**COUNCIL OFFICE EXTENSION – N6/2013/1938/MA**

I write to object to aspects of the Council's proposed extension.

Council Chamber Entrance

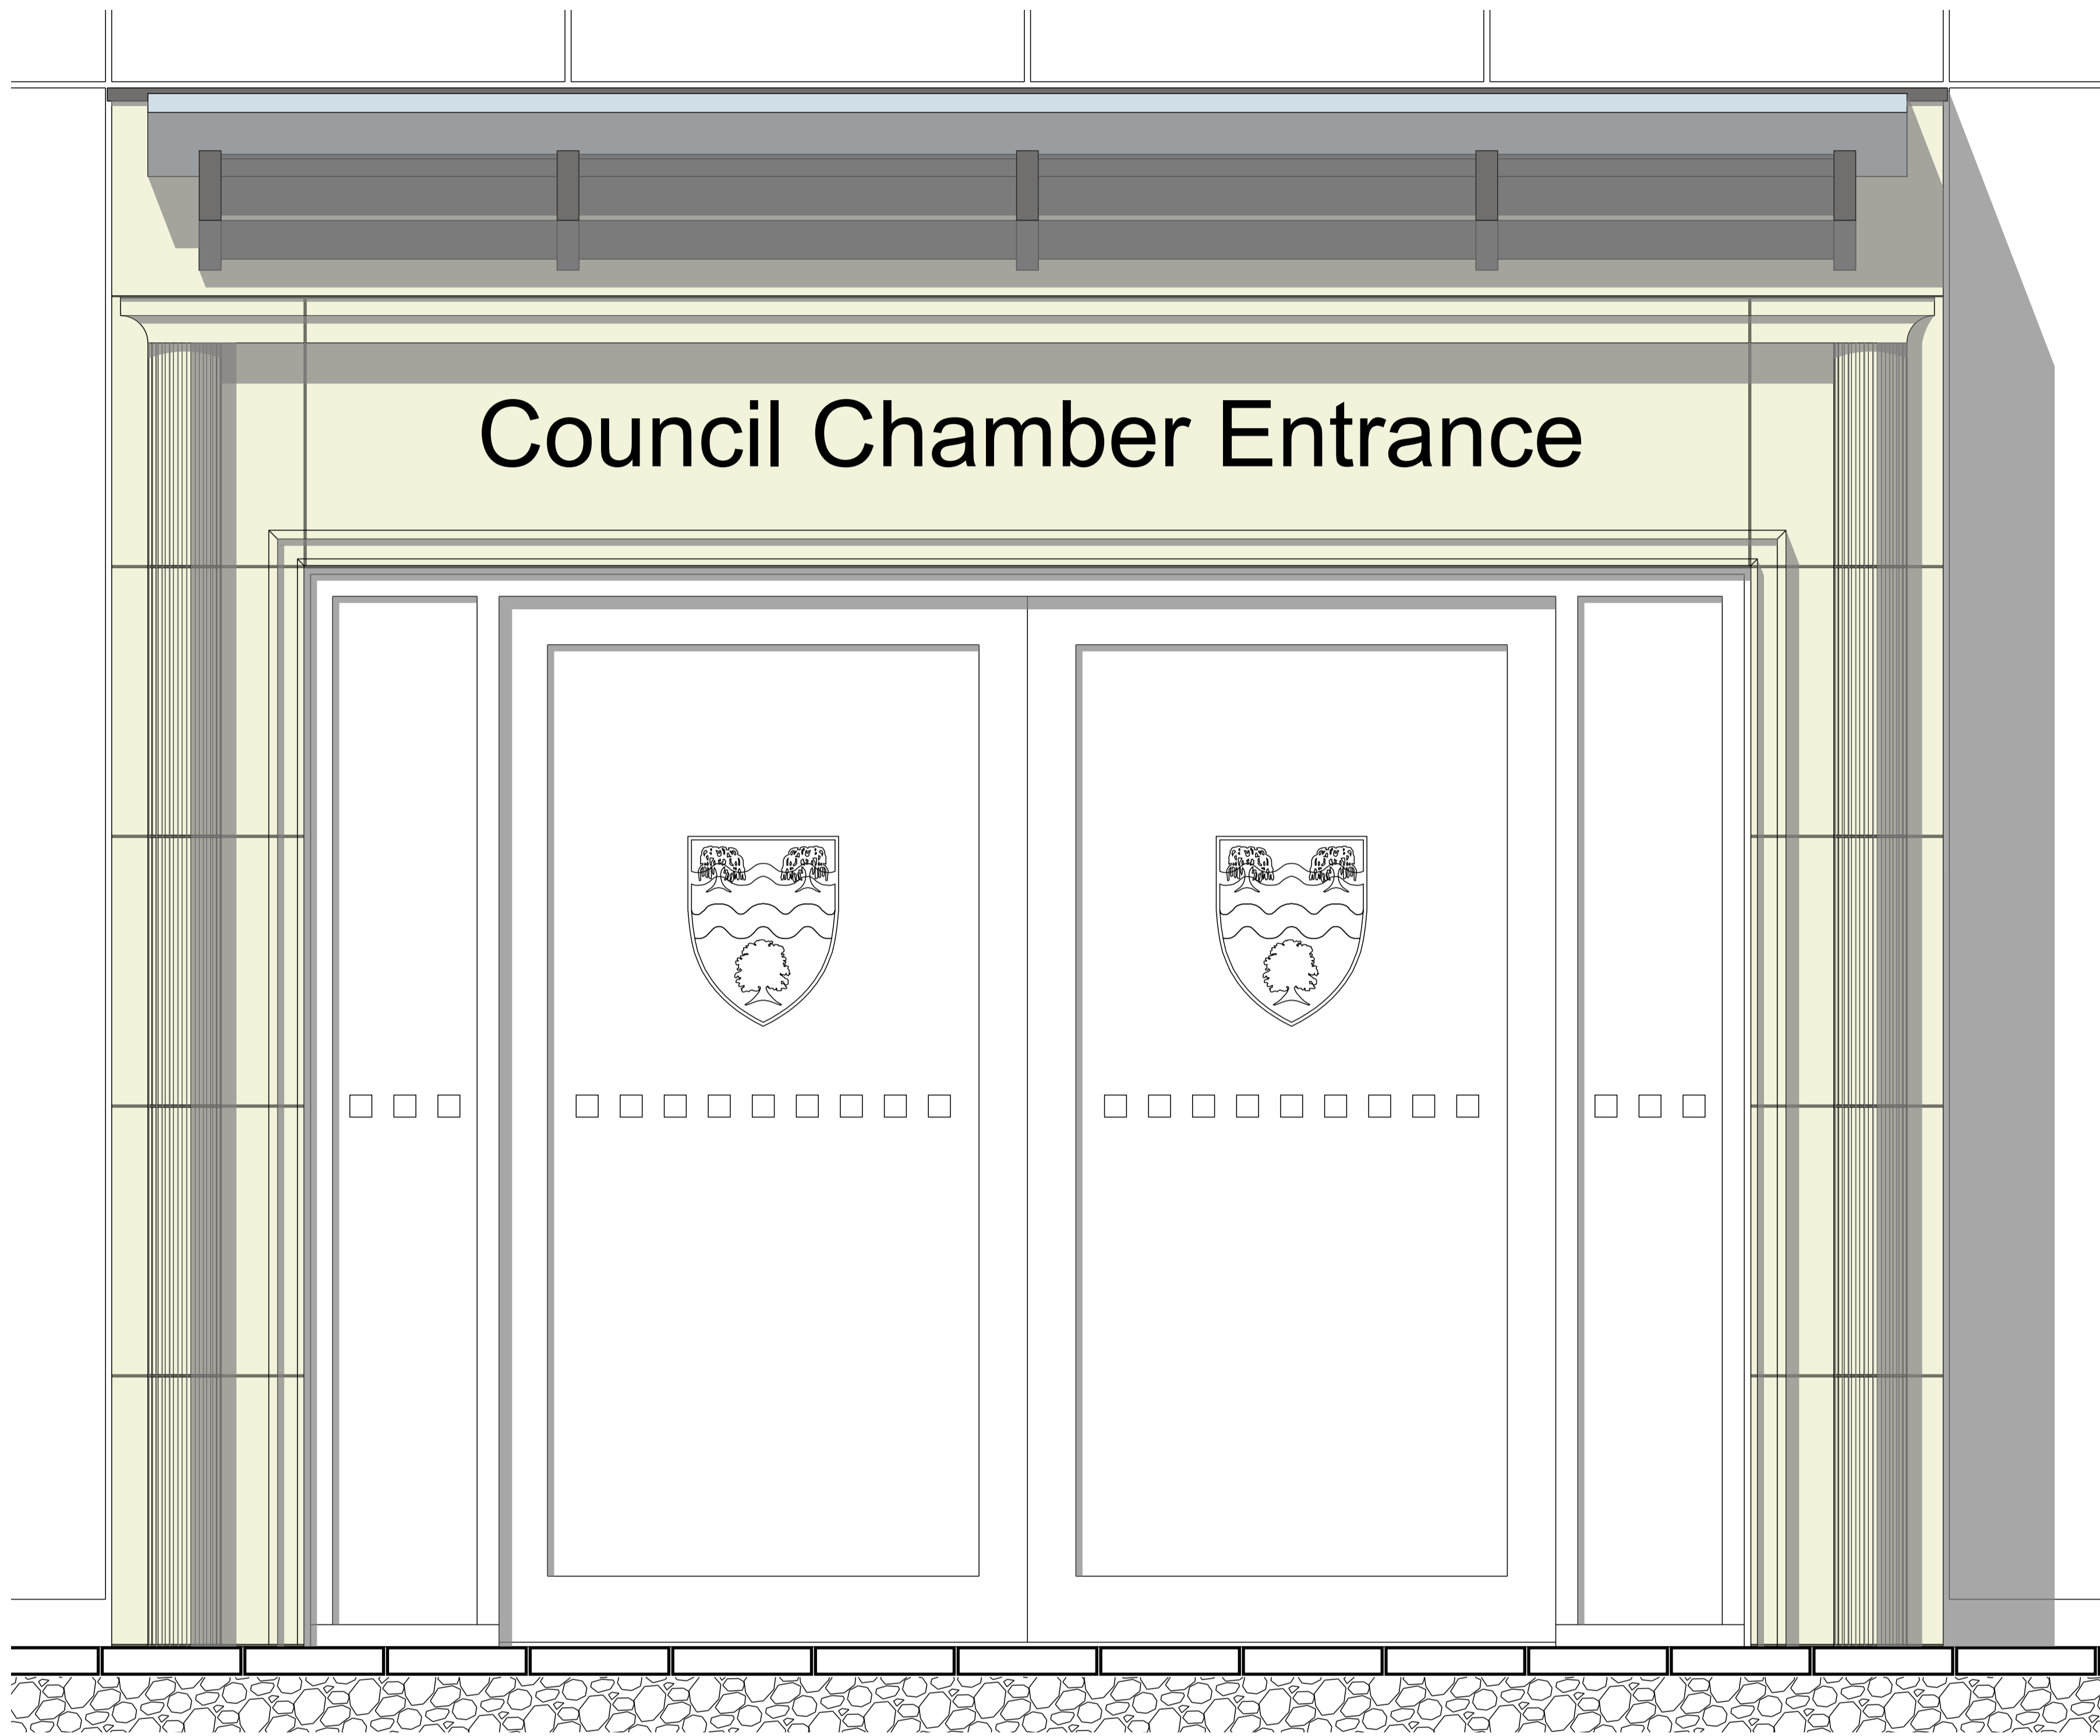
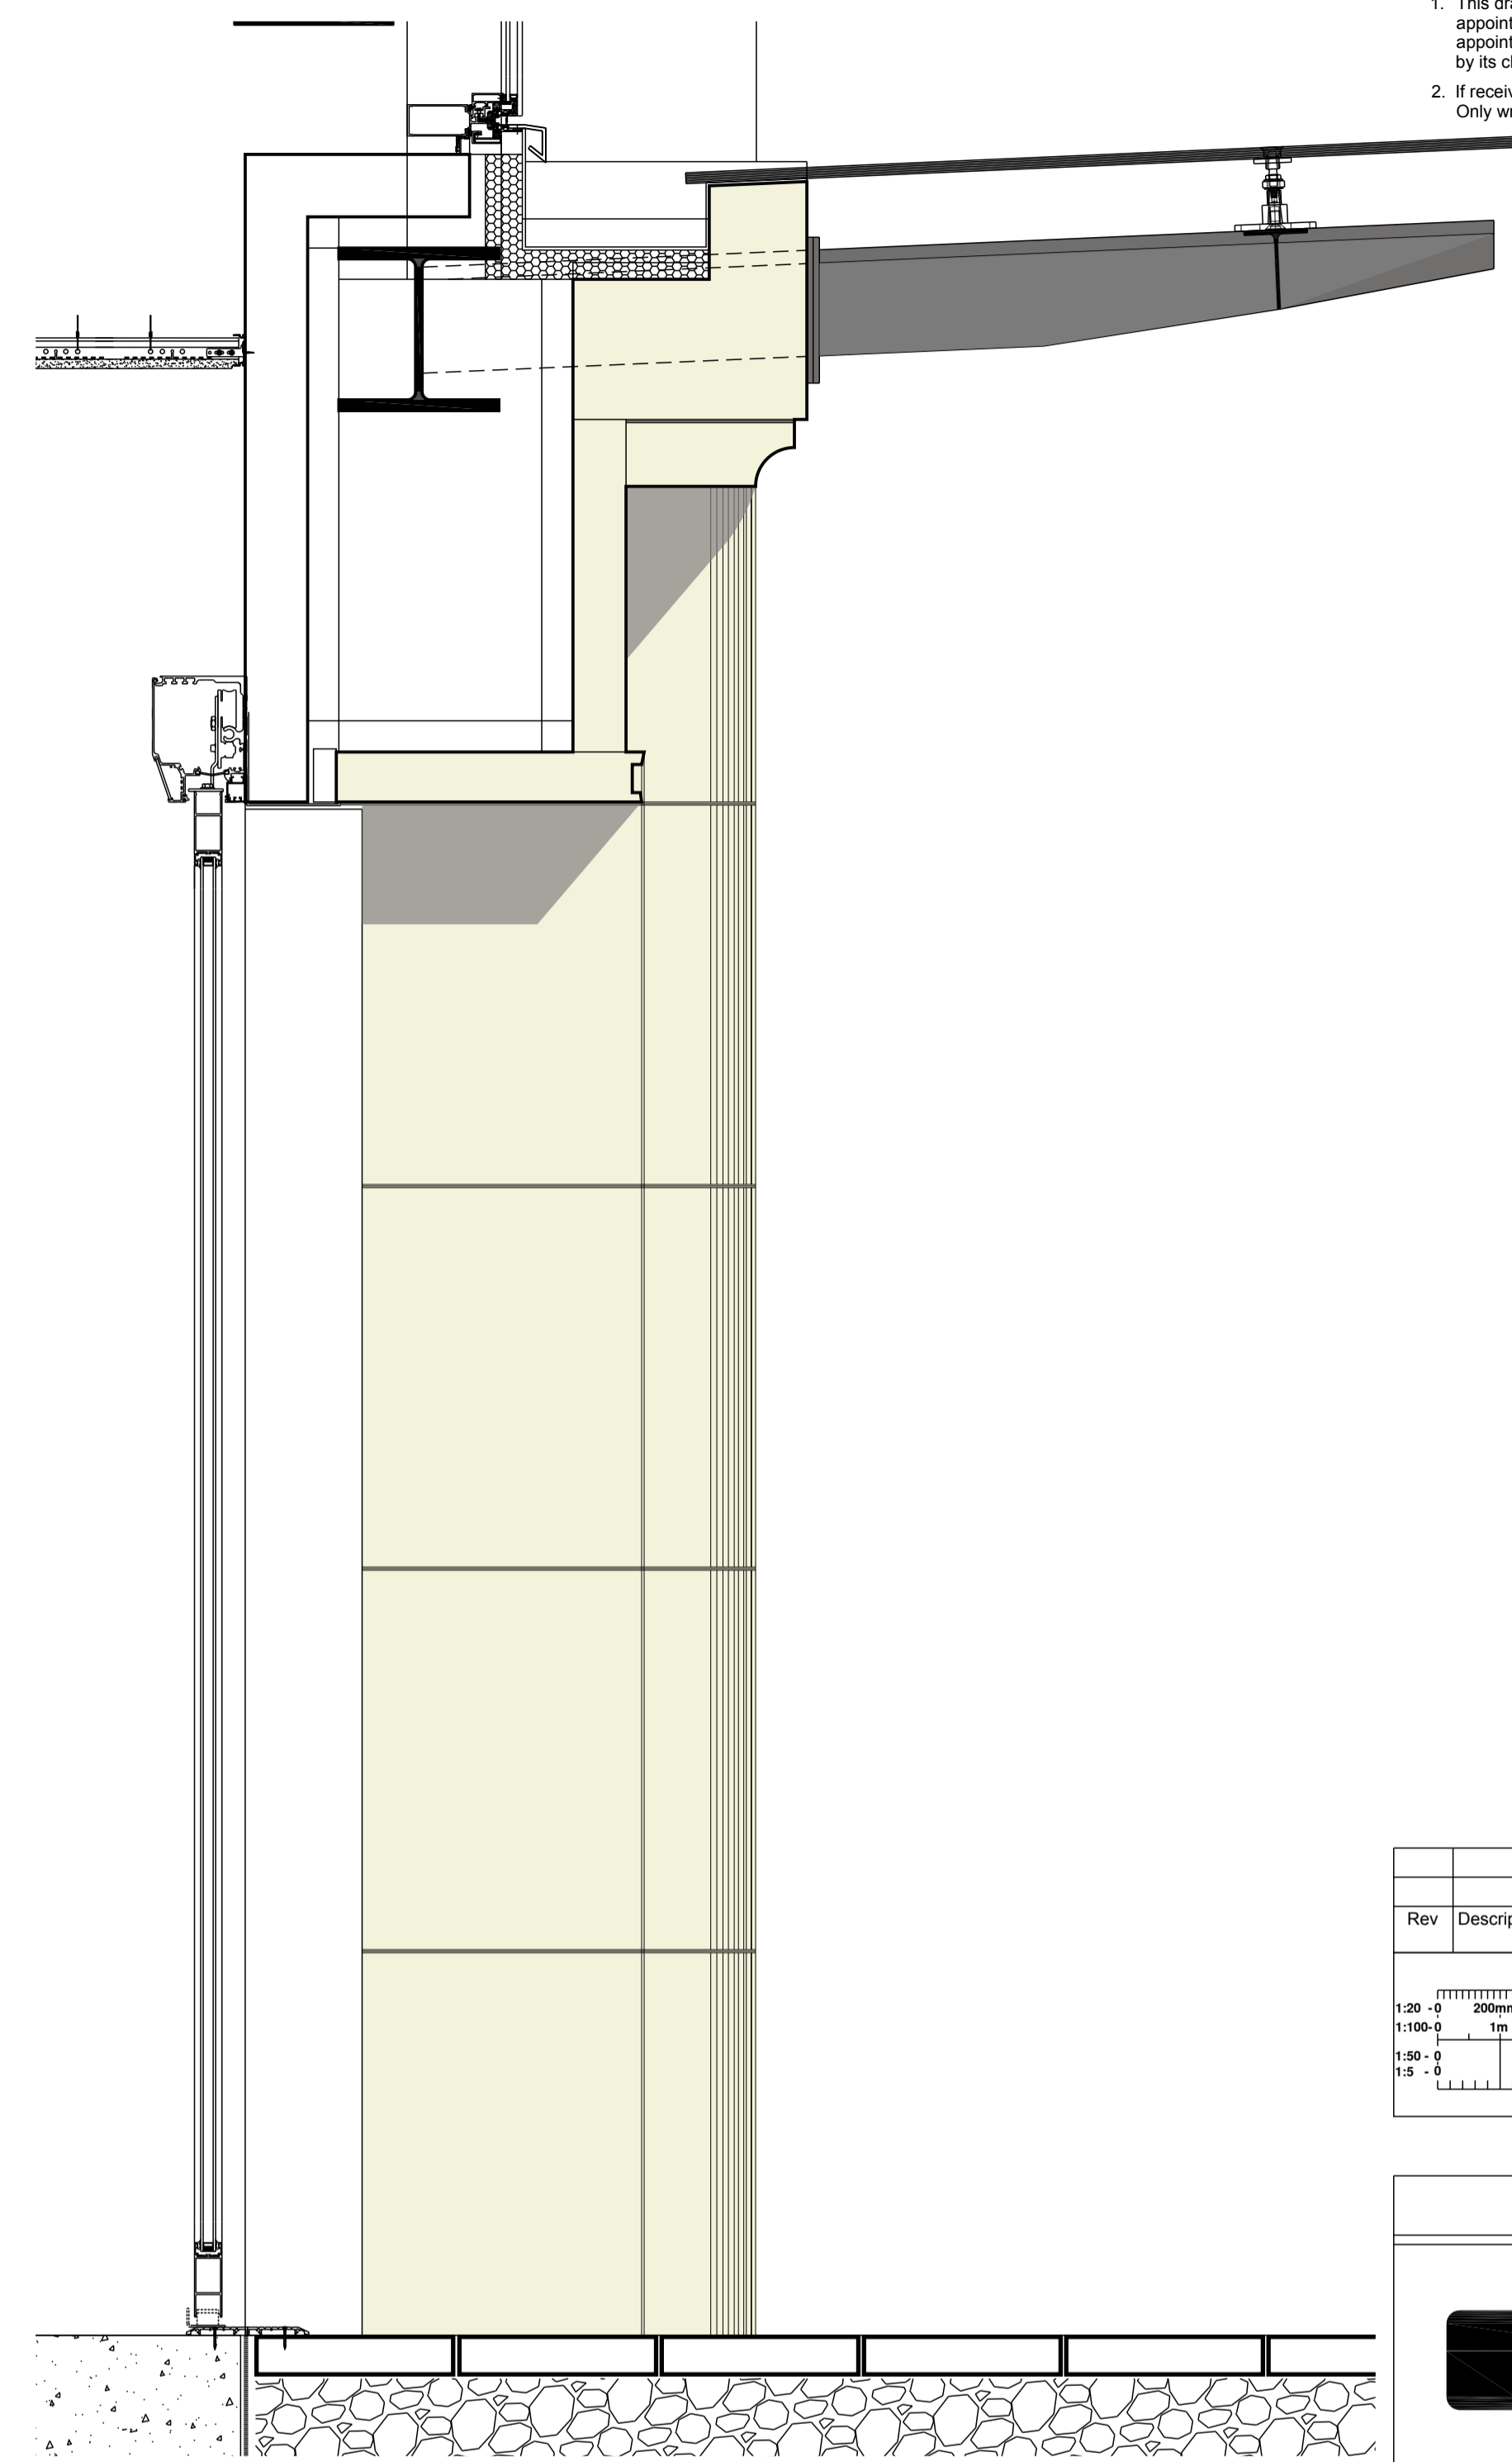
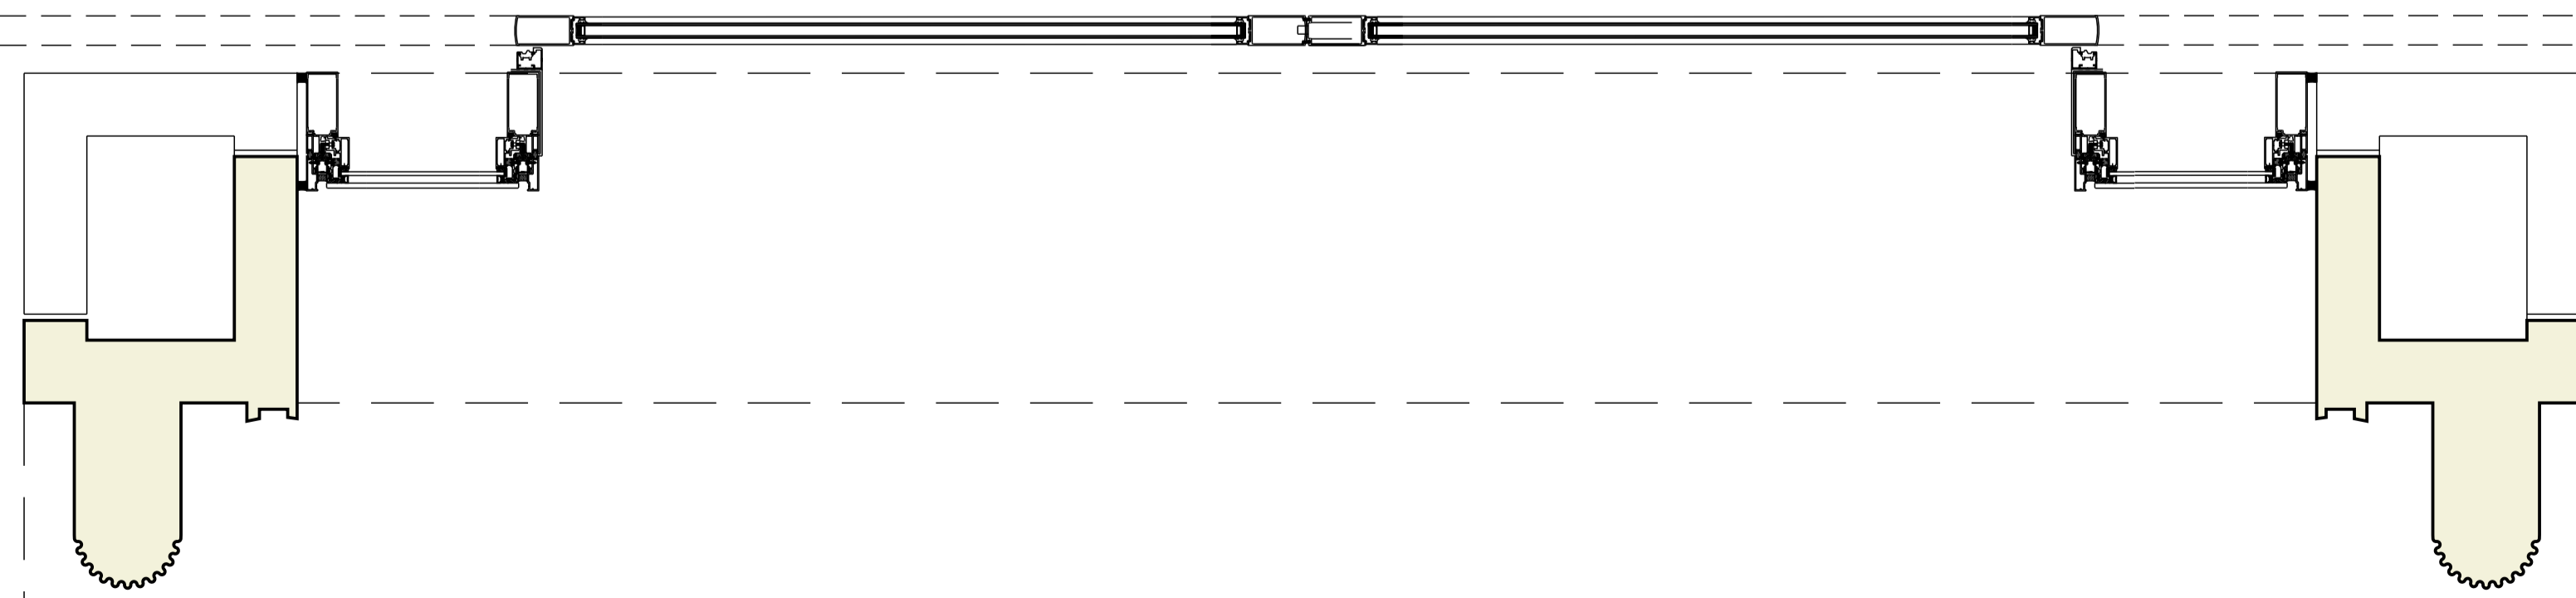
My objection is to the façade of the 'Council Chamber Entrance' shown on the planning application. The use of such a large scale glazed façade is not in keeping with the Garden City ethos or the Estate Management Scheme. Policy EM1 covers extensions and alterations to existing properties and I believe that the proposed glazed façade is in clear contravention of this Policy. Whilst recognising that Policy EM1 is focussed on residential properties, the Policy wording does not appear to restrict its application solely to residential properties. In any case the Policy does no more than express what would be considered good architectural practice in a conservation area.

In my opinion the façade should comprise brickwork and fenestration 'in keeping with the existing building.'
